**KIRKLEES METROPOLITAN COUNCIL
INVESTMENT & REGENERATION SERVICE**

**DELEGATED DECISION FOR DISCHARGE OF CONDITION -
NOTIFICATION OF TELECOMMUNICATIONS DEVELOPMENT**

Reference no.	2021/N /92175/E
Site Address	Wakefield Road, Earlsheaton, Dewsbury, WF12 8AH
Description	Prior notification for proposed 18.0m Phase 8 Monopole C/W wrapround Cabinet at base and associated ancillary works
Recommending Officer	Callum Harrison

DECISION – PRIOR NOTIFICATION REFUSED

Title:
260 PROPOSED ELEVATION

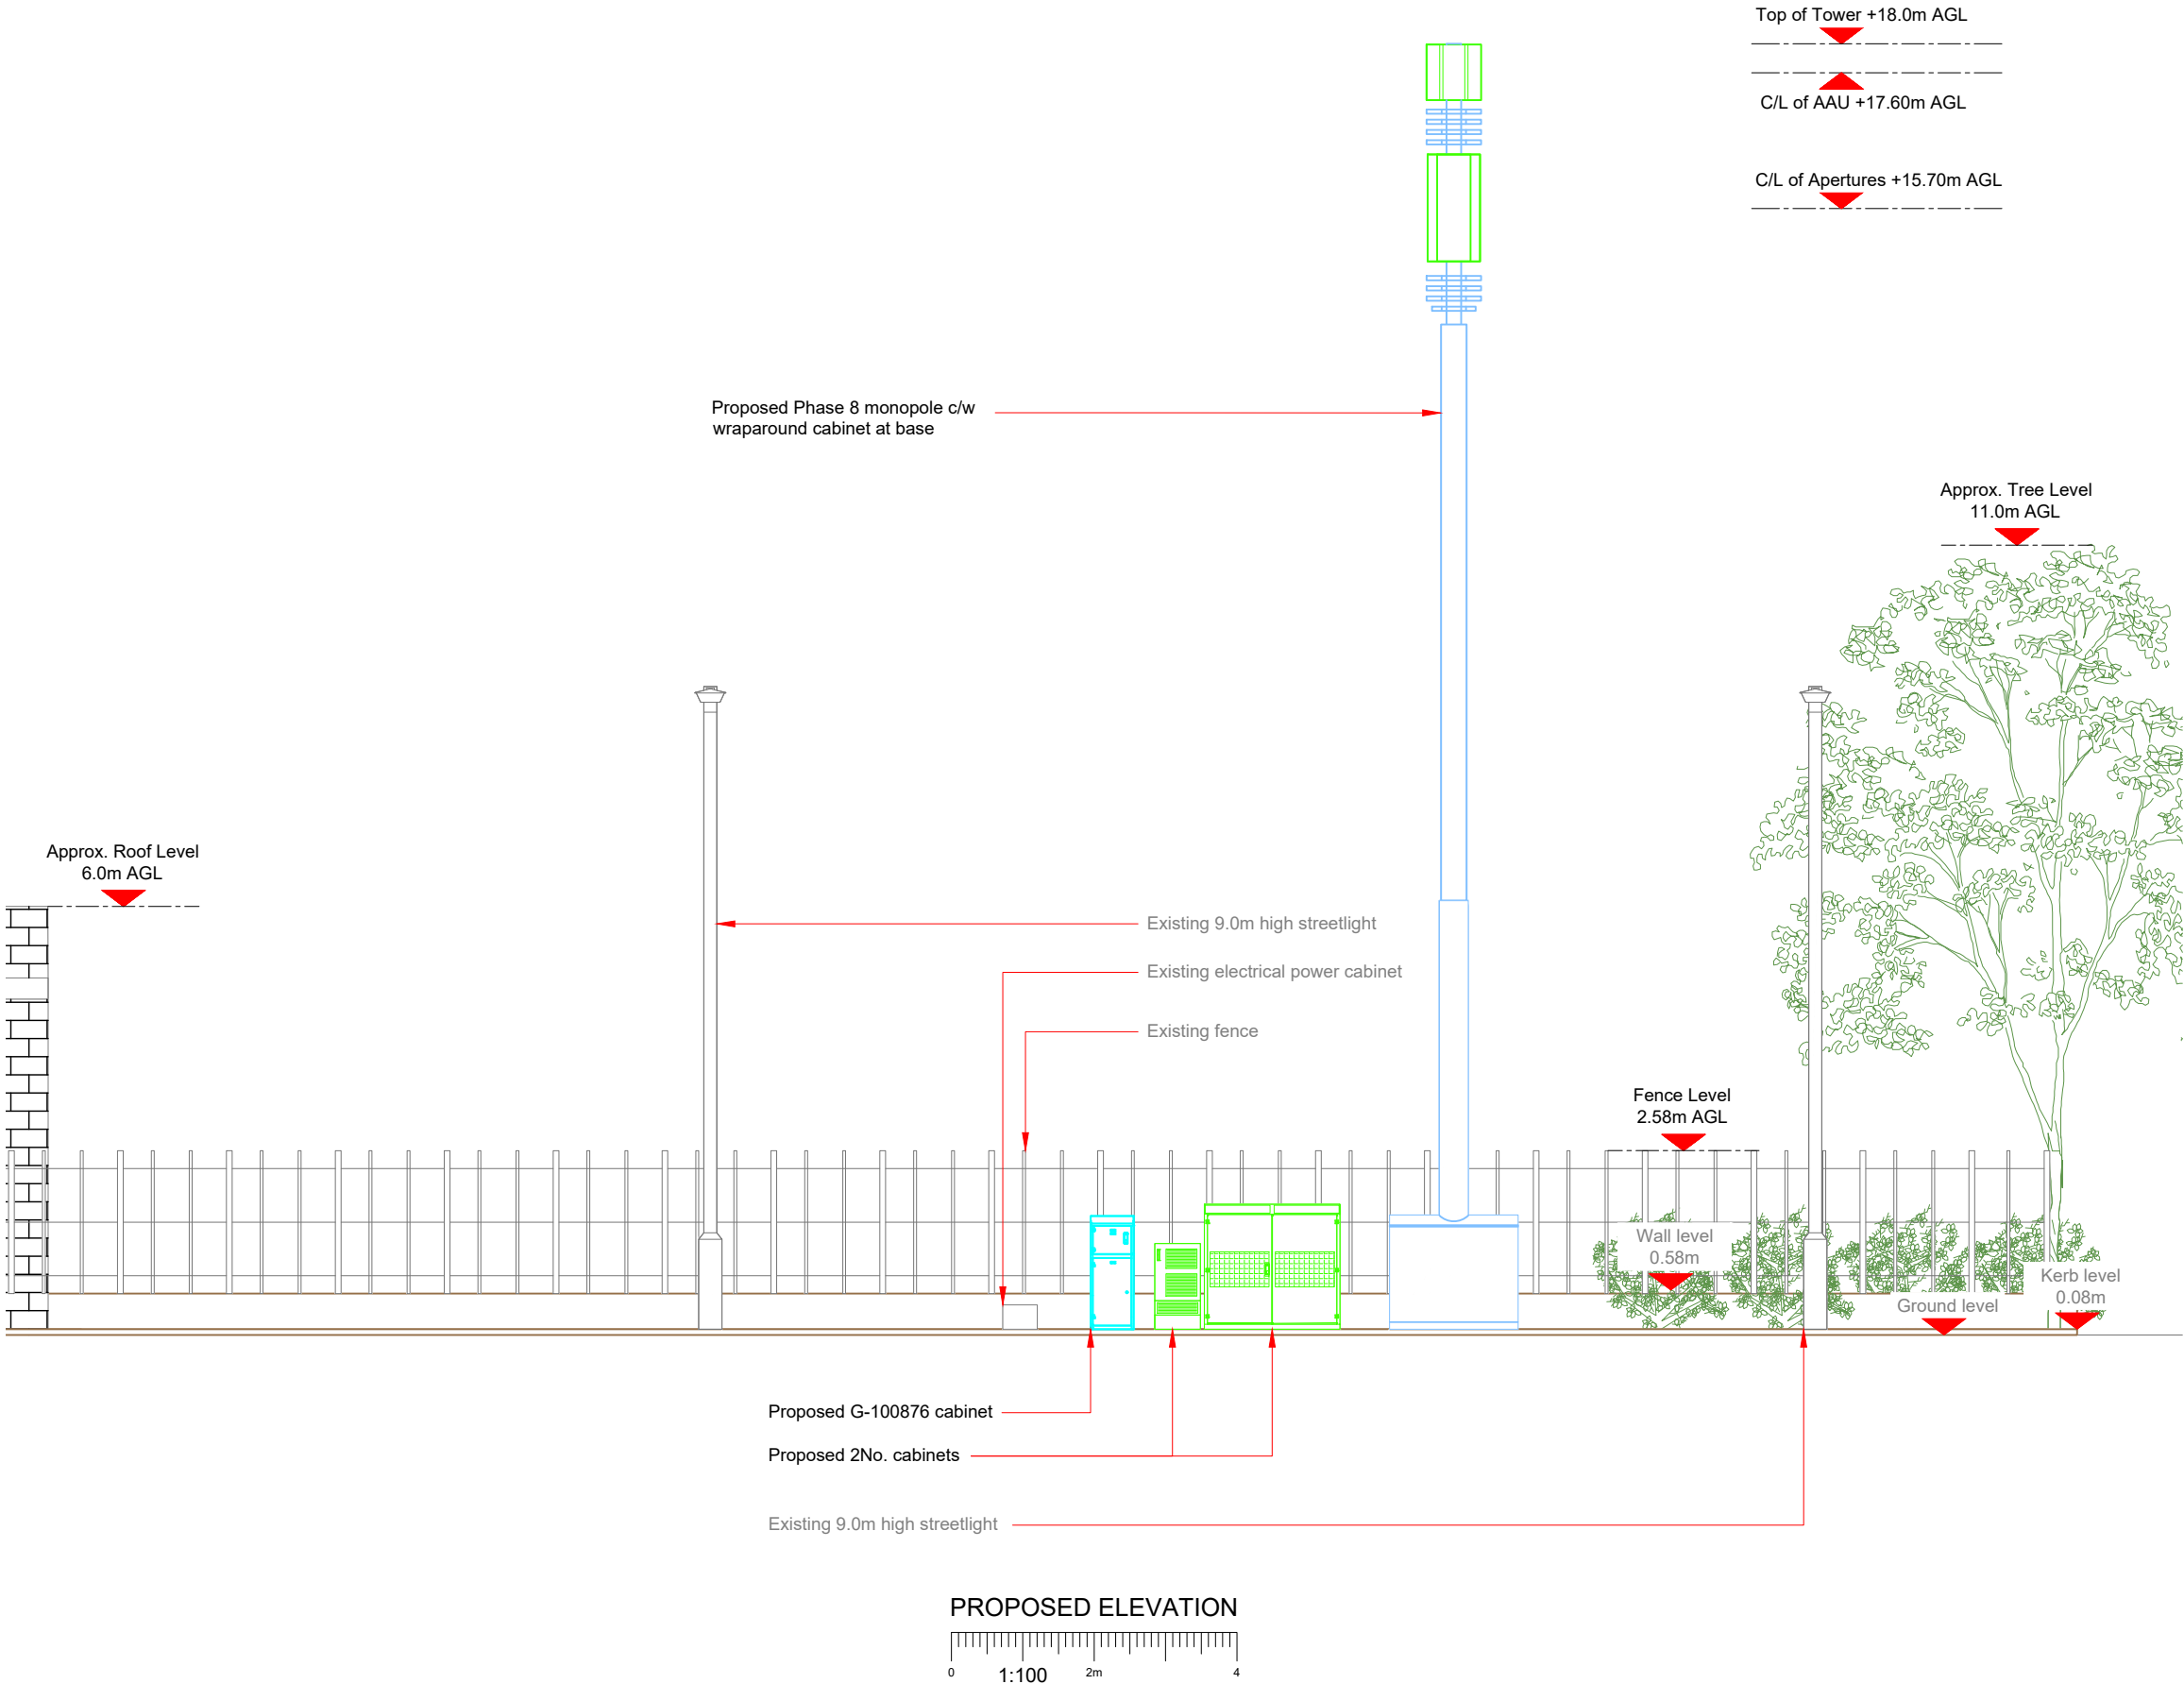
Officers note that the mast is to be erected on the public footpath by the junction of Wakefield Road and Park View. In the submitted documents, the agent states that they have 'considered the detailed siting and design carefully to ensure that the scheme has a limited impact on the locality and general visual amenity.' And that they 'have carefully placed and designed the scheme to ensure the principles of good siting and appearance are adhered to. The overall impact of the installation on the environment is limited.' Officers dispute this, given the applicant could have hardly found a more prominent position than highway land of a Primary A Road. The site, despite being set near to a health centre and petrol station, is also set within a primarily residential area. Given this, it can be stated that the mast is in a highly prominent position. The 18m high mast will effectively double the height of any built form in the area given that the buildings and existing street furniture do not appear to exceed approx. 9m. The trees referenced on the submitted drawings are 17m away from the application site, nevertheless these trees do not exceed 11m. Therefore, the proposed 18m height of the mast will mean it would appear incongruous in the street scene where existing development is relatively low level. The steel grey colour also would not appear aesthetically pleasing in the street scene. Whilst officers note the existing lampposts are grey, these are very slim in comparison to the proposed mast. A more modern, less industrial colour should be used, nevertheless whatever colour is used would not overcome the incongruous size and siting of the mast.

This viewpoint is reinforced by the appeal decisions APP/Q3305/W/17/3185165 and APP/T0355/W/20/3265640 whereby 15m masts (3m smaller than those proposed) were deemed incongruous given the unsympathetic design, which includes the height. The overall size of the mast would appear incongruous in this area, which is primarily residential with low

level development. The design can thus not be considered in keeping with the townscape as required by policy LP24 of the Kirklees Local Plan. Whilst officers note that similar proposals have been considered acceptable regarding visual amenity within Kirklees, none of these have been set within such a strongly formed residential area but have been approved in more commercial area.

Overall, whilst significant weight has been given to telecommunications development by the NPPF, for the reasons given, the proposed siting and appearance of the proposed mast would be unduly harmful to the visual amenity of the area and would be in breach of Policy LP24a of the Kirklees Local Plan.

1. The proposed mast, by reason of its siting, size and appearance in regard to form and colour would be a visually intrusive and incongruous feature in the streetscape appearing wholly out of scale with the surrounding residential properties and failing to respect the character of the area. The proposed siting and appearance of this mast would be contrary to Policy LP24a of the Kirklees Local Plan and chapters 10 and 12 of the National Planning Policy Framework.
